40 OCEAN DRIVE, FERRING, WEST SUSSEX, BN12 5QP

Planning Department
Arun District Council

Ref: - Planning application FG/34/21/HH

Concerning planning application for 50 Ocean Drive Ferring my objections are as Follows :-

REAR (w)

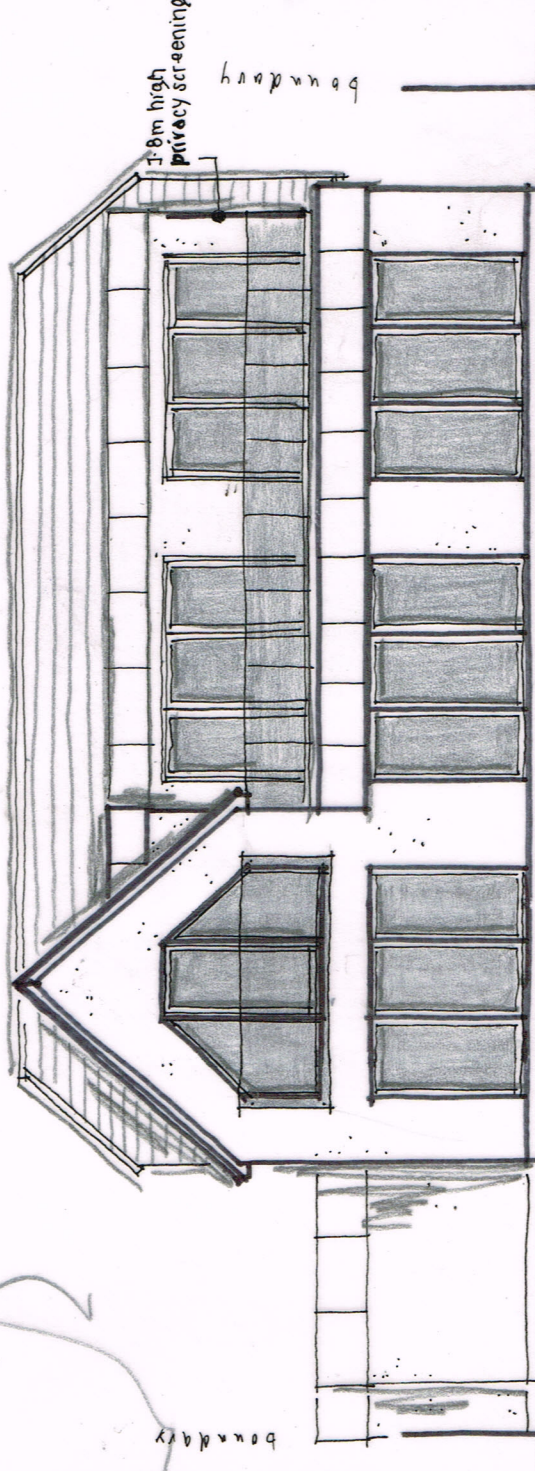
- 1 This seems to be a huge development compared to the size of the existing property which would not fit comfortably on this site.
- 2 Two small bungalows north of the proposed development would be starved of light.
- 3 The second level rear balcony would overlook a number of properties and would be totally out of order.
